CITY OF ALBUQUERQUE

October 15, 2018

Re: SAVSU
4209 Balloon Park RD NE
Traffic Circulation Layout
Engineer's/Architect's Stamp **09-19-18 (E17D077)**

G1.0a

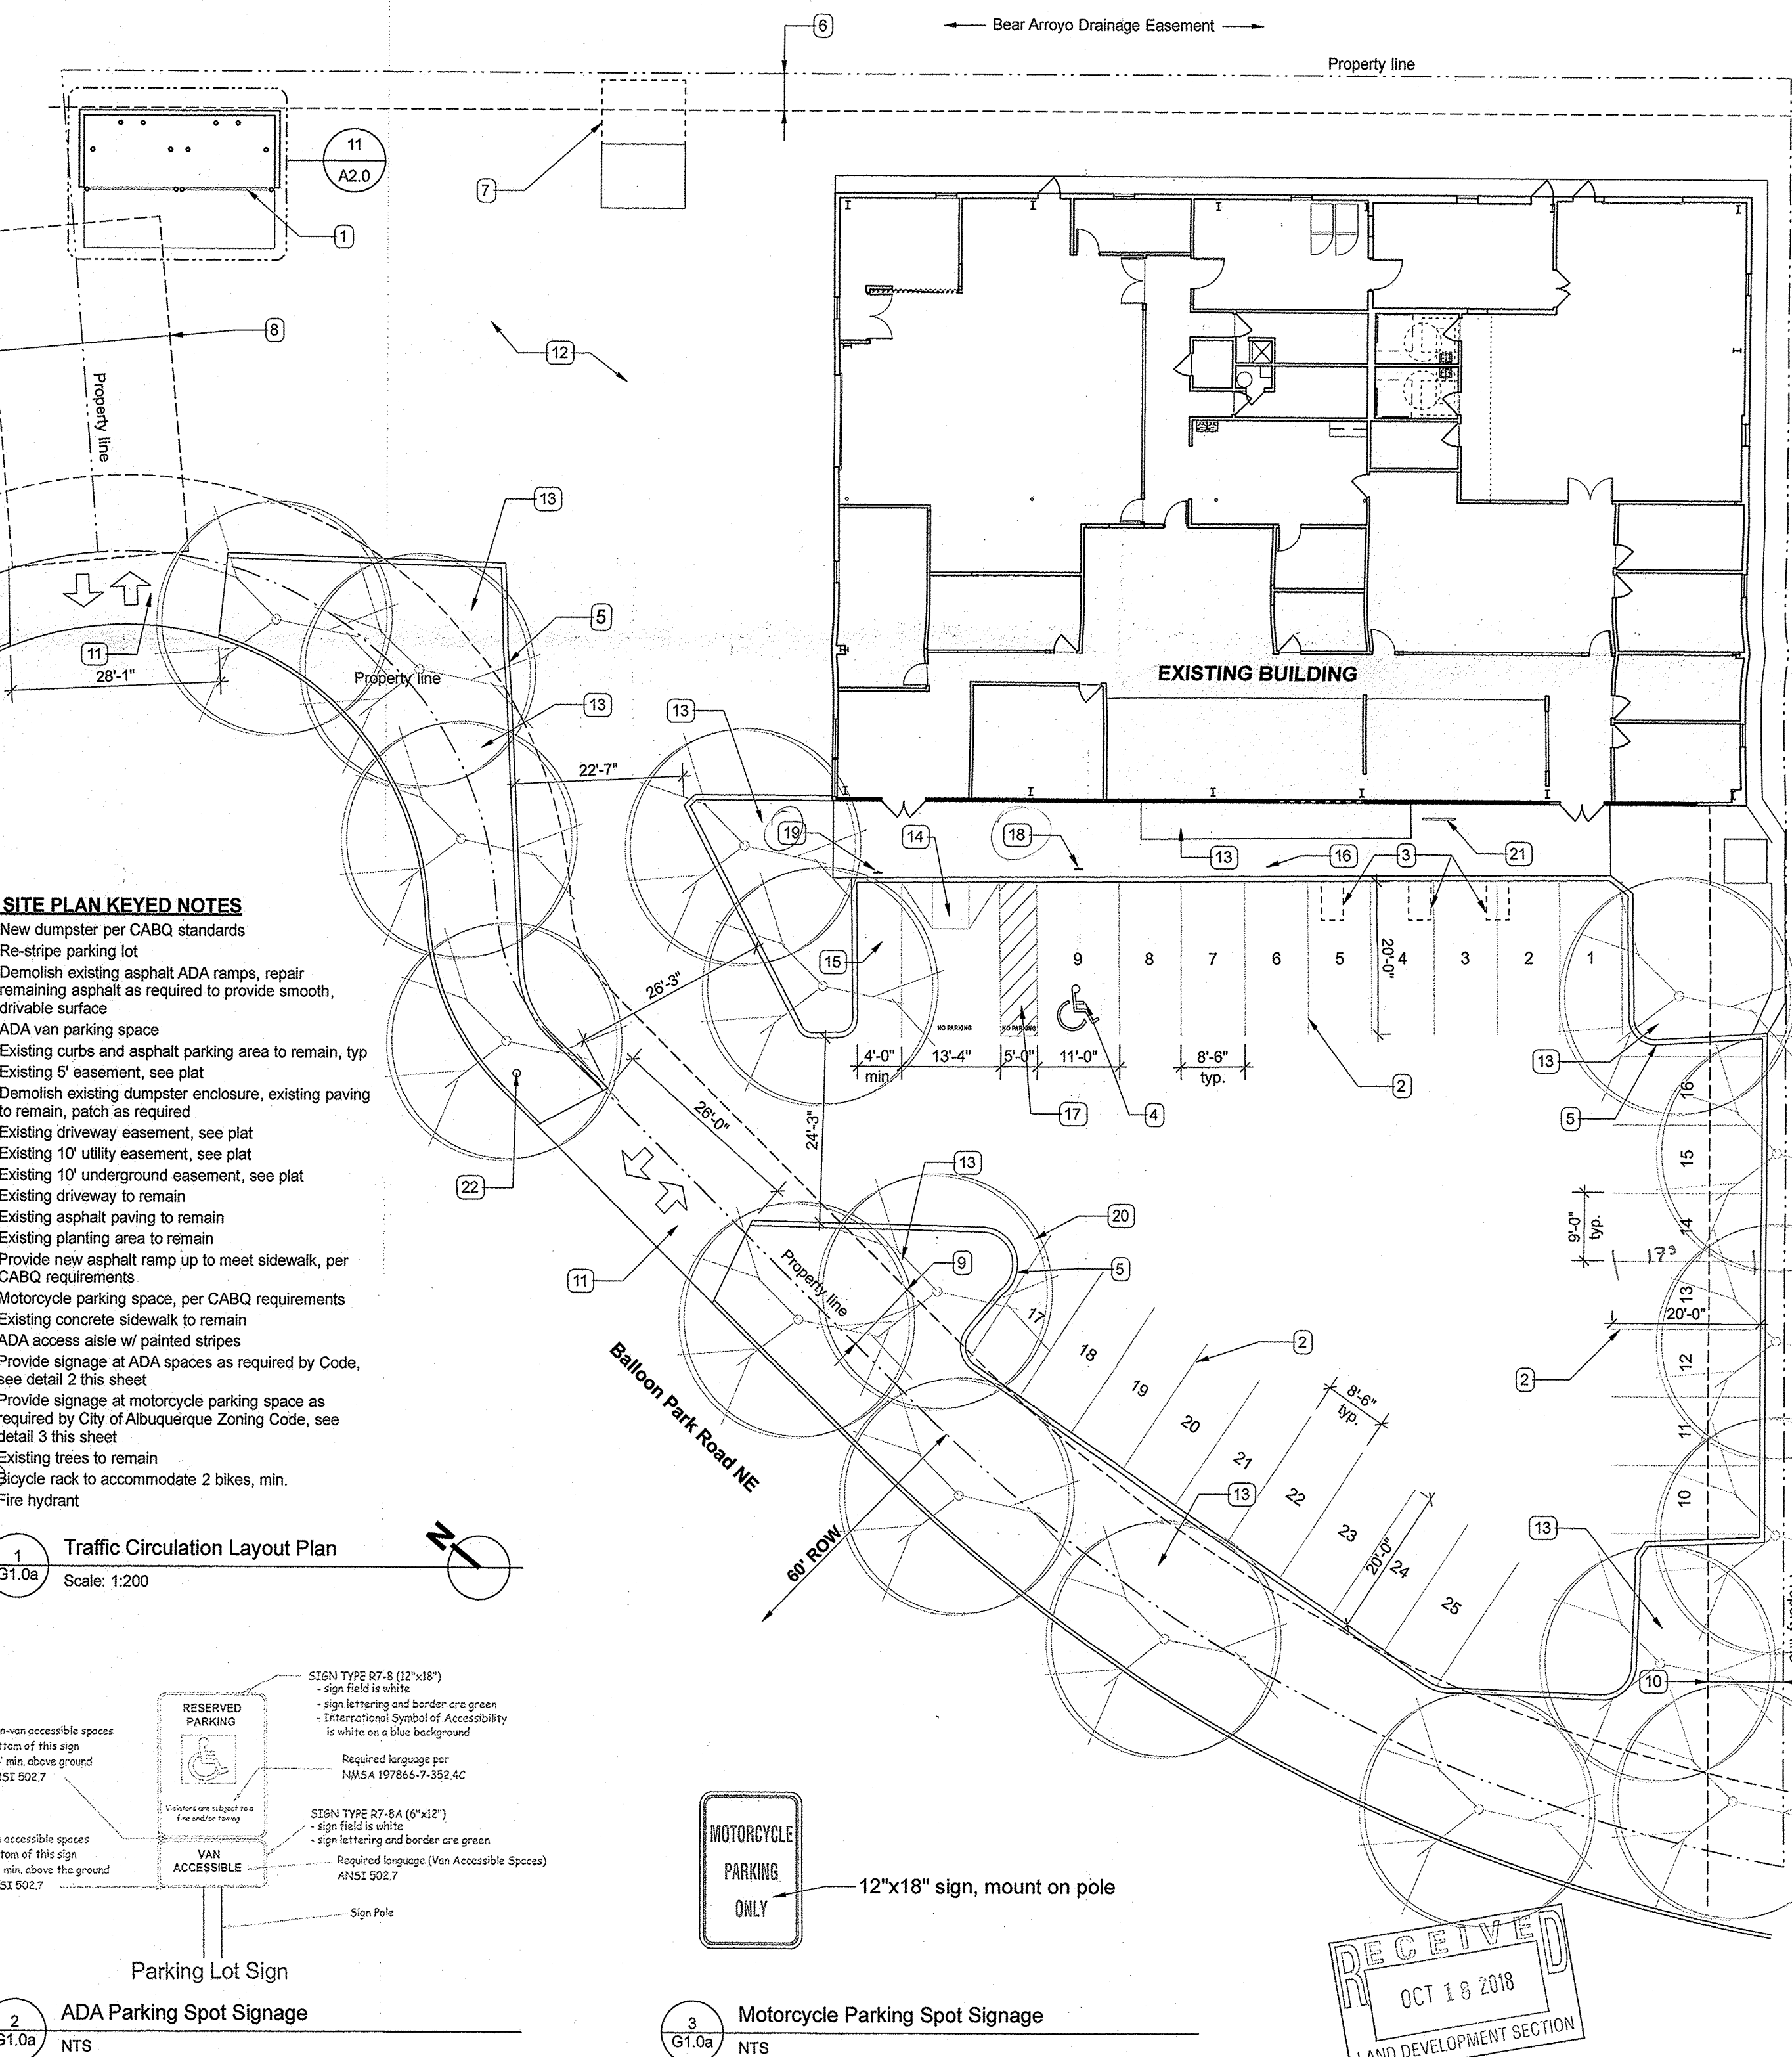
1. Please remove all bubbles from the TCL.
2. Remove "AREA OF WORK" that points to existing building or replace it with "existing building" note.
3. Motorcycle parking spaces shall be designated by its own conspicuously posted upright sign, either free-standing or wall mounted per the zoning code.
